**From:** [Rob Green](#)  
**To:** [Price, Robert](#)  
**Cc:** [Wilson, Andy](#); [Betts, Simon](#); [A38 Derby Junctions](#)  
**Subject:** RE: A38 Derby Junctions - SoCG McD  
**Date:** 02 April 2020 11:50:45  
**Attachments:** [image001.png](#)

- 1a. My client does not agree to the proposed closure of the A38 access
- 1b. The outcome of the A52 junction modelling is agreed, however, concerns remain over the proposed junction layout and its ability to operate safely. Should you wish to split this point into two elements, then we will agree the junction modelling

DELIVERY TRACKS

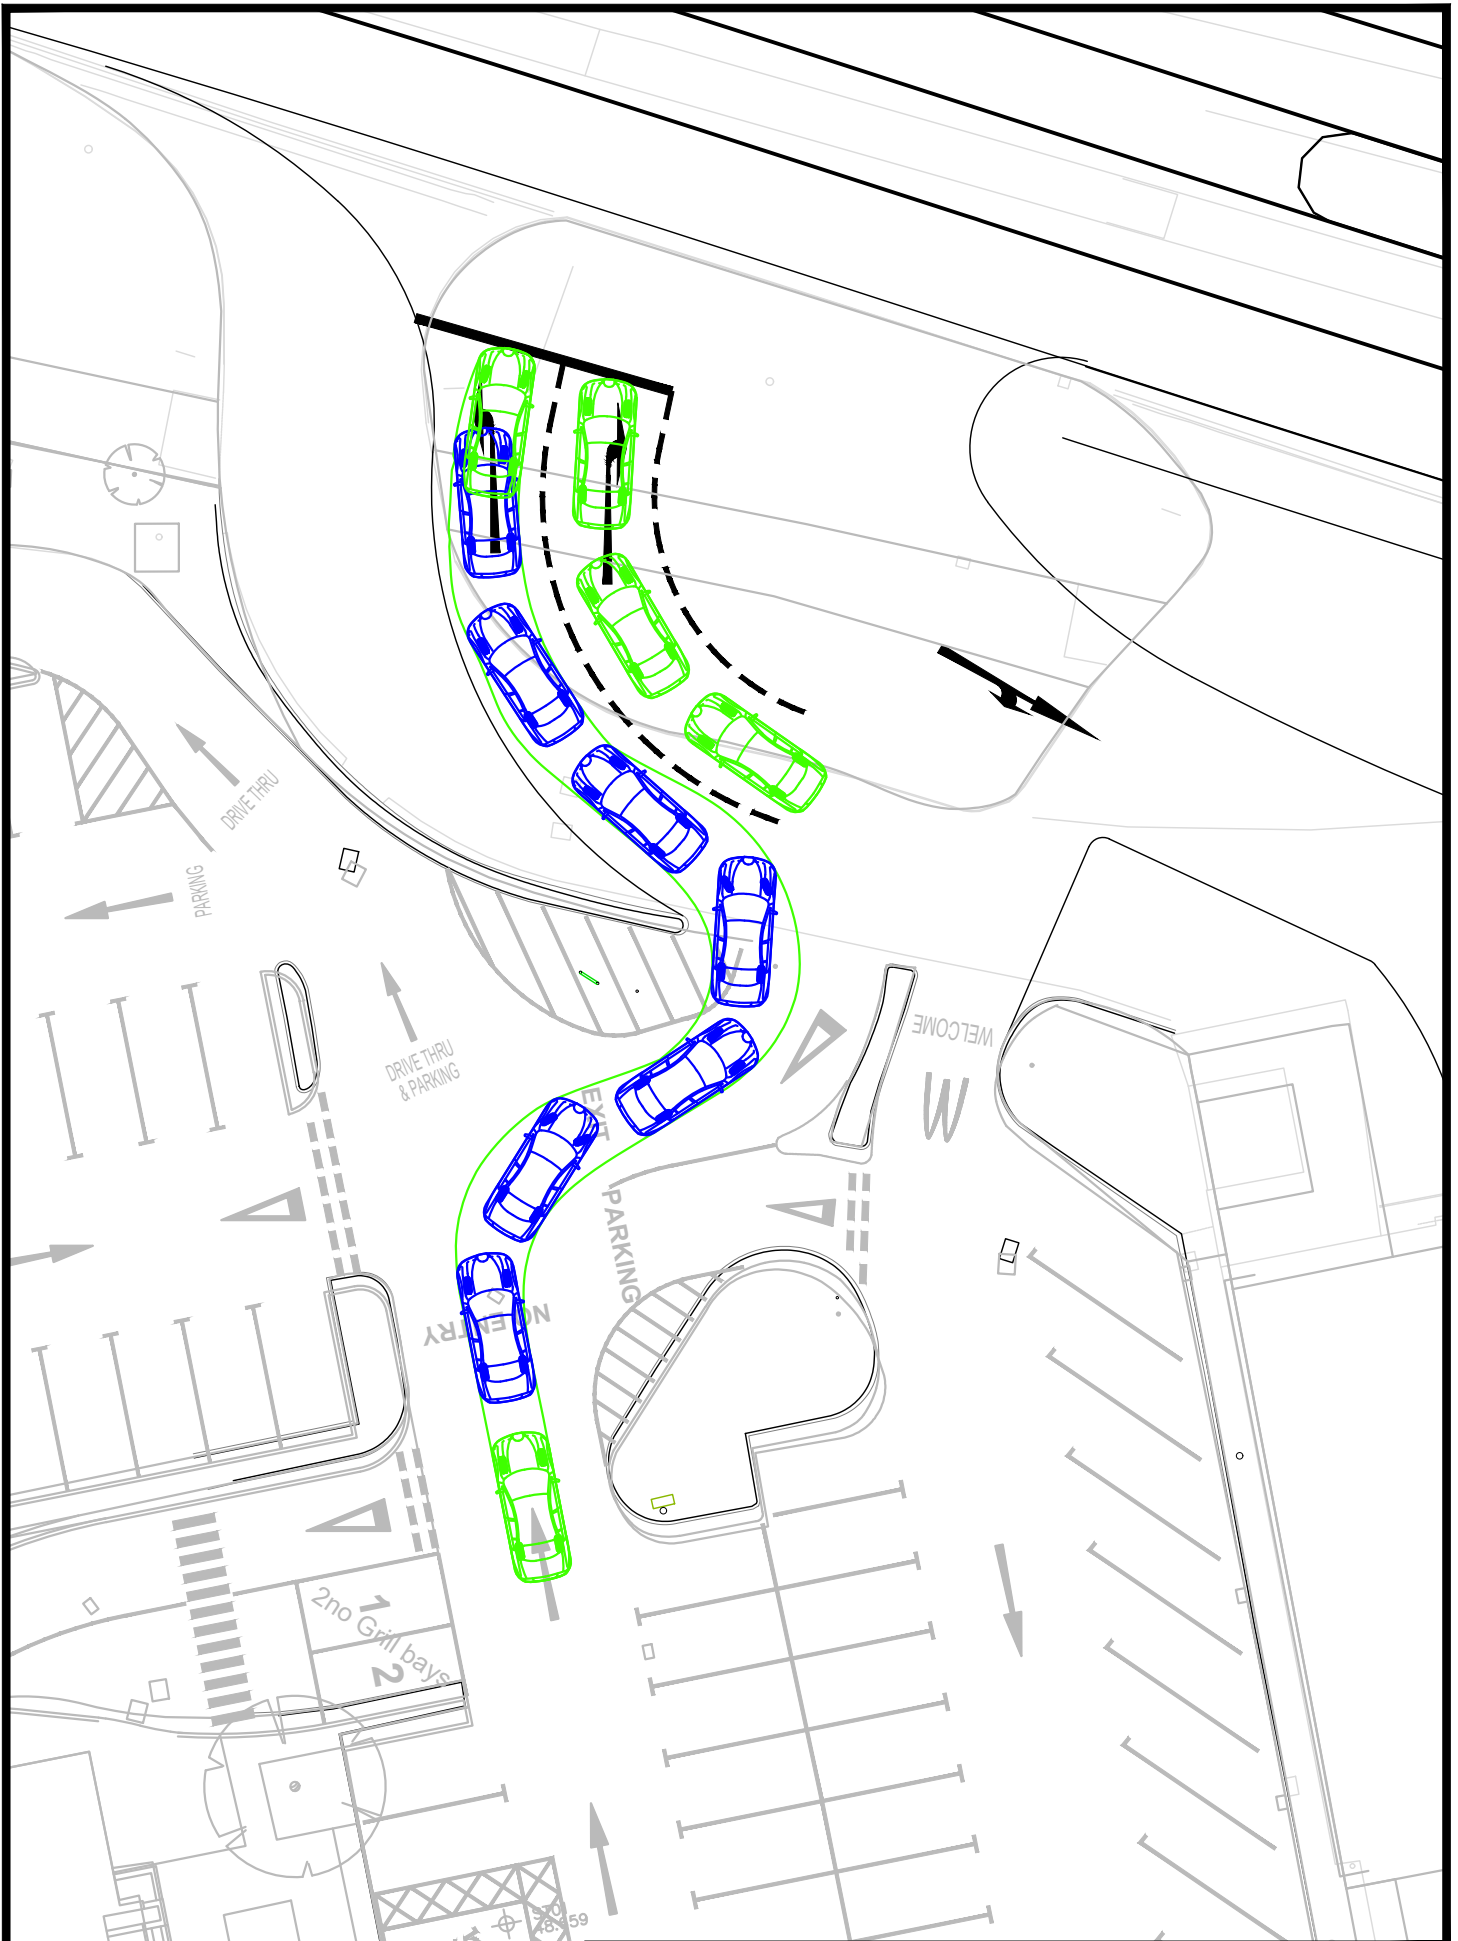
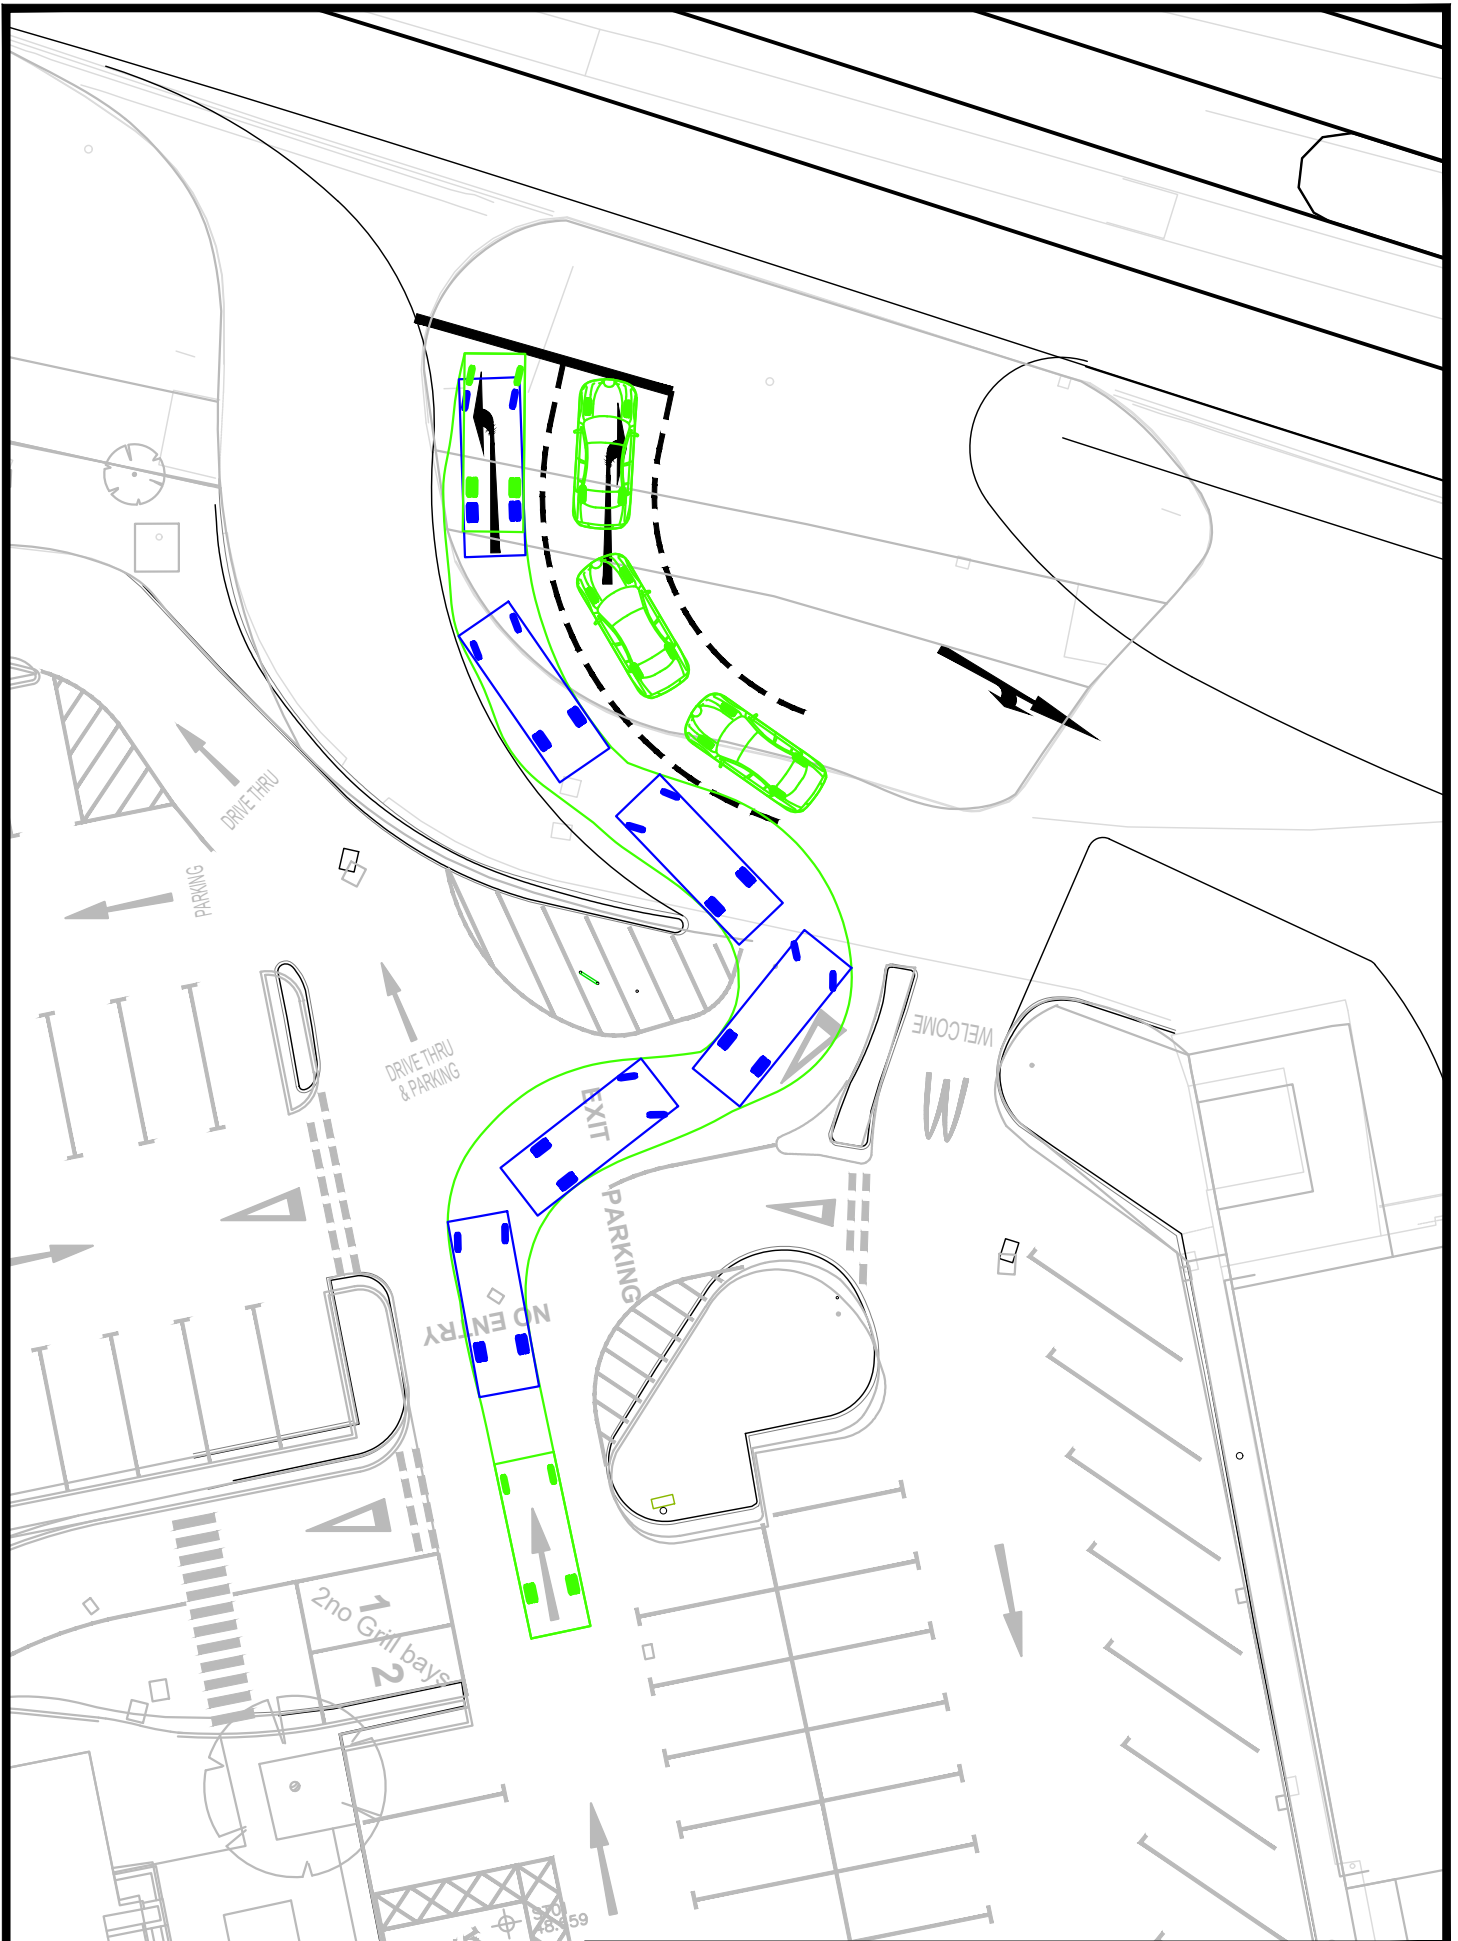
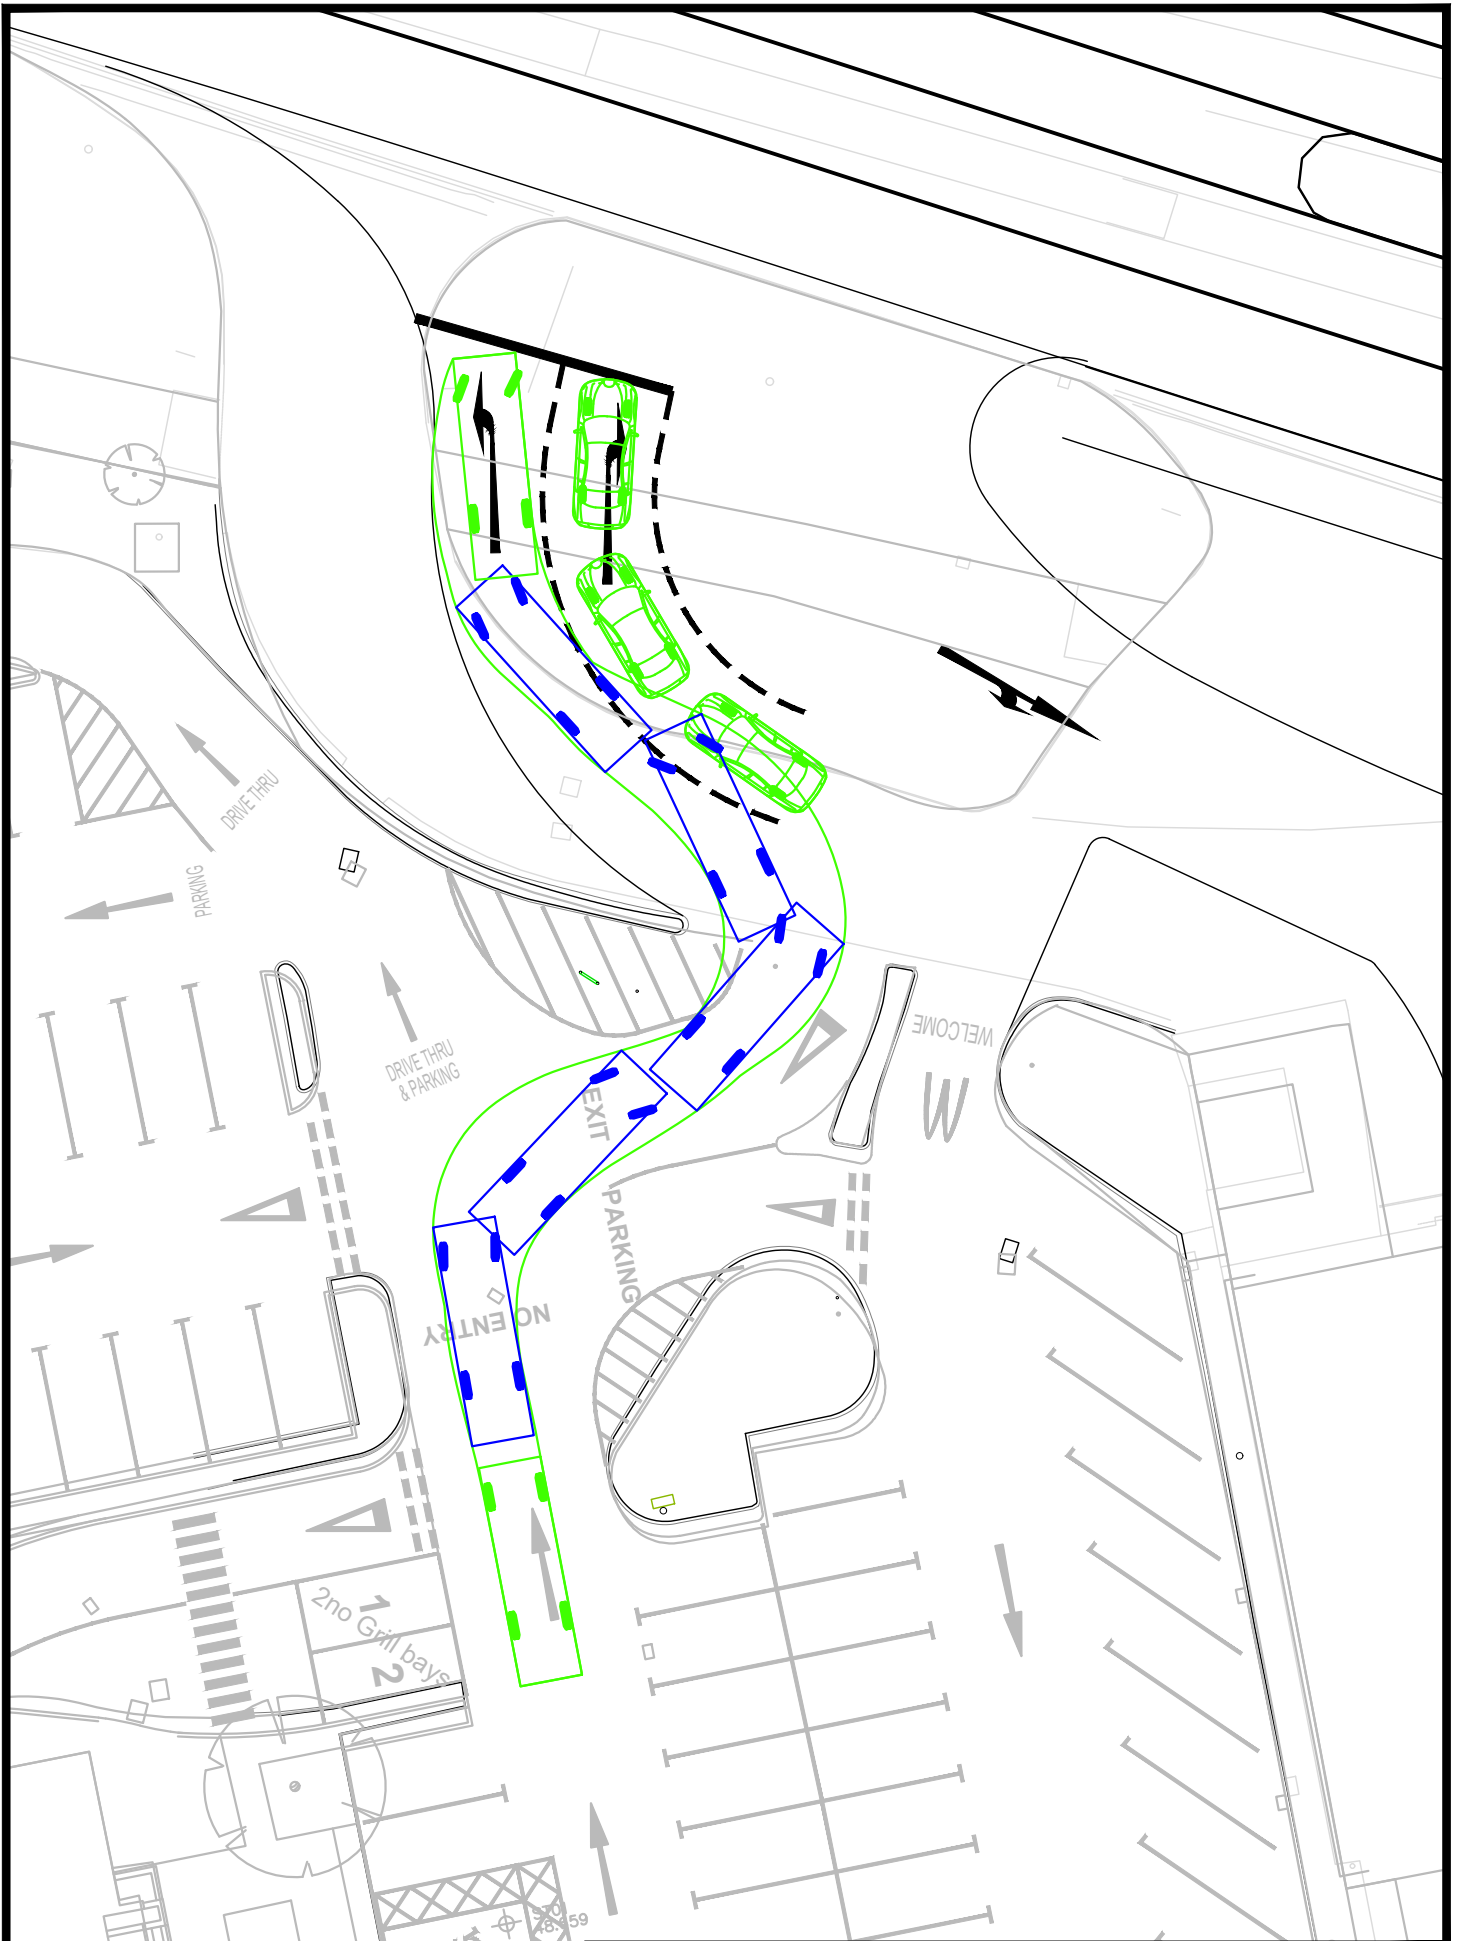
- 2b. Agreed – Servicing via Enfield Road will cease
  - 2c. Agreed – Refuse collection will be via the A52 and McDonald's will accept the management burden of co-ordinating deliveries and refuse to avoid each other arriving at the same time.

- 2d. Not agreed, McDonald's do not have rights for the updated manoeuvres on Euro Garages controlled land.
- 3a. Remains under discussion – if a detailed signal design layout is provided, this can be reviewed further and potentially agreed.
